OUT18/6607

**Santos Narrabri Gas Project (SSD6456)
Comment on the Response to Submissions (RTS)**

I refer to your email of 23 April 2018 to the Department of Industry in respect to the above matter. Comment has been sought from relevant branches of Lands and Water and Department of Primary Industries.

Figure 3-6 Nominated Gunnedah-Oxley Basin groundwater monitoring bores

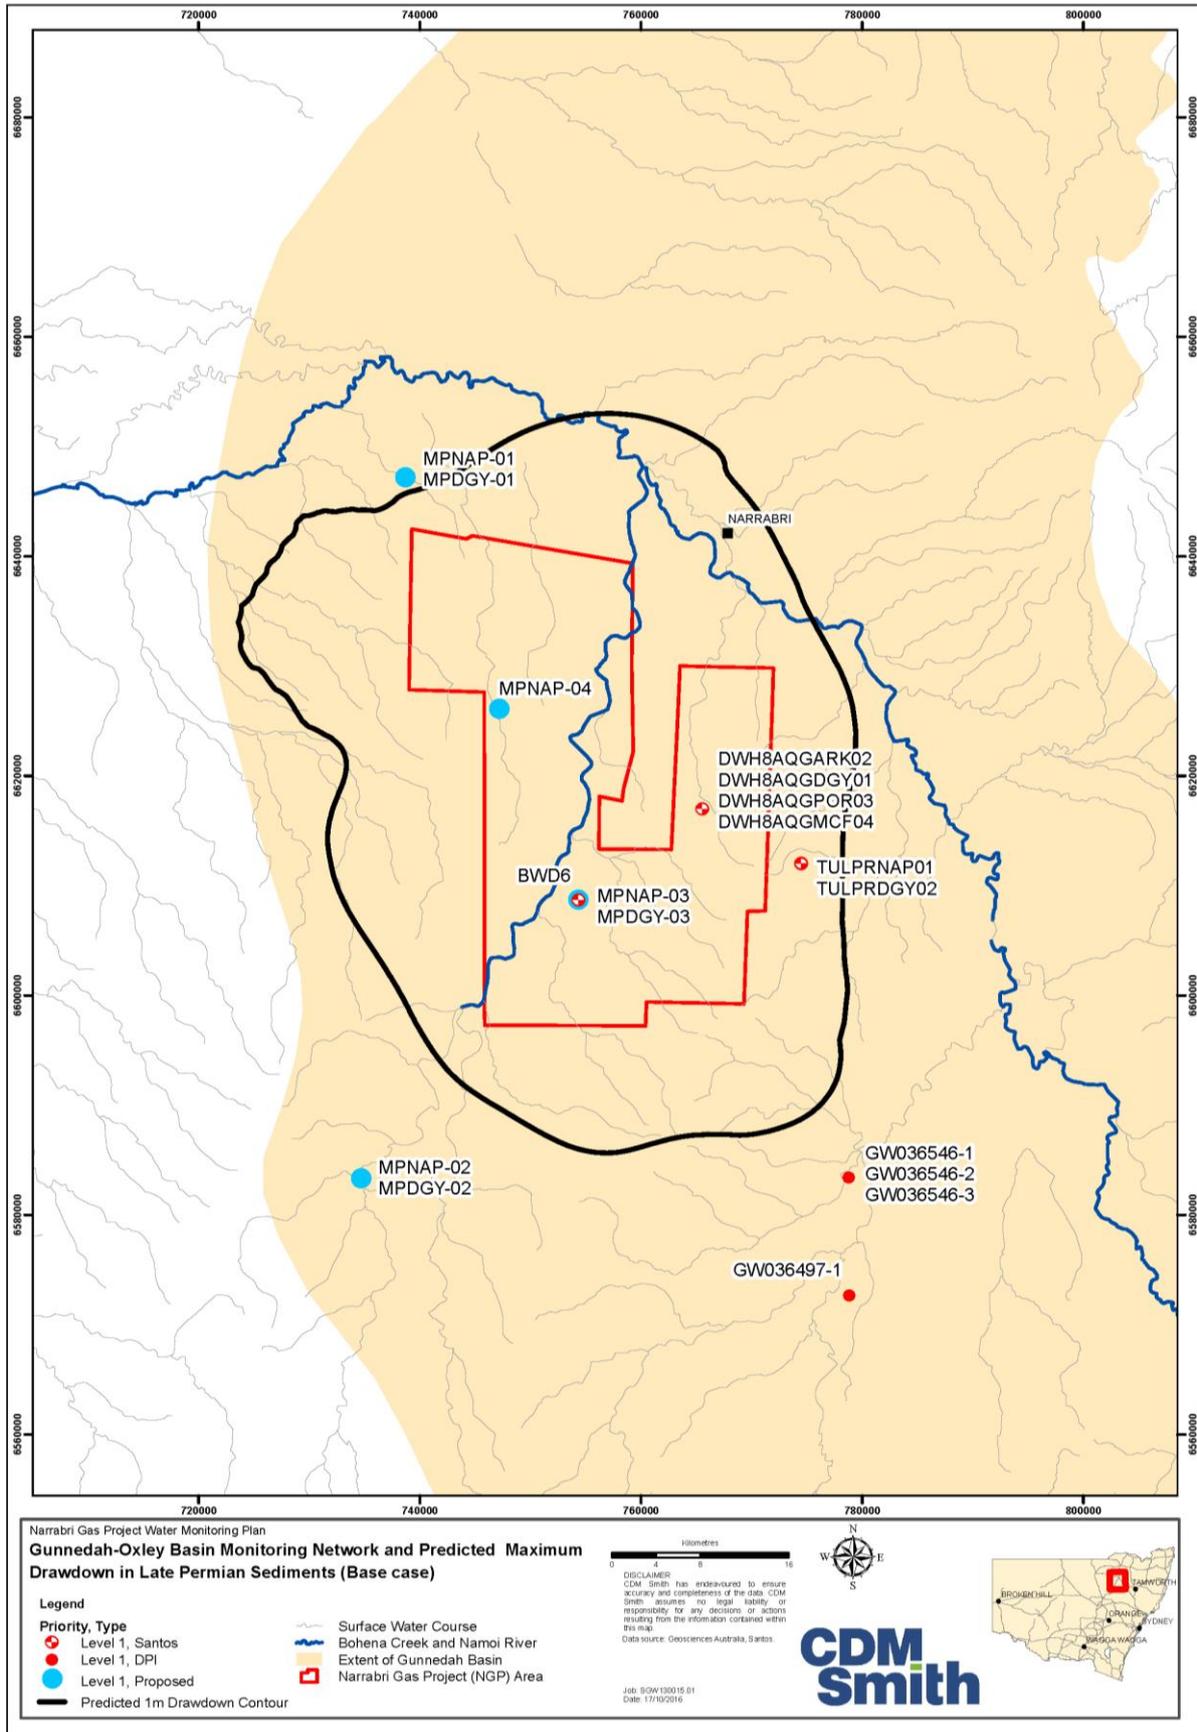
- e. Clarification of the discrepancy between the number of Gunnedah-Oxley Basin monitoring sites reported in the Water Baseline Report compared to the sites identified in the Water Monitoring Report and justification of why not all existing Gunnedah-Oxley Basin bores were used in the Water Baseline Report.

It is noted a number of the sites currently included in the proposed management response trigger network for the Great Artesian Basin (GAB) and the Gunnedah-Oxley Basin (GOB) were assigned to the incorrect formation as identified in the Department's comments on the EIS.
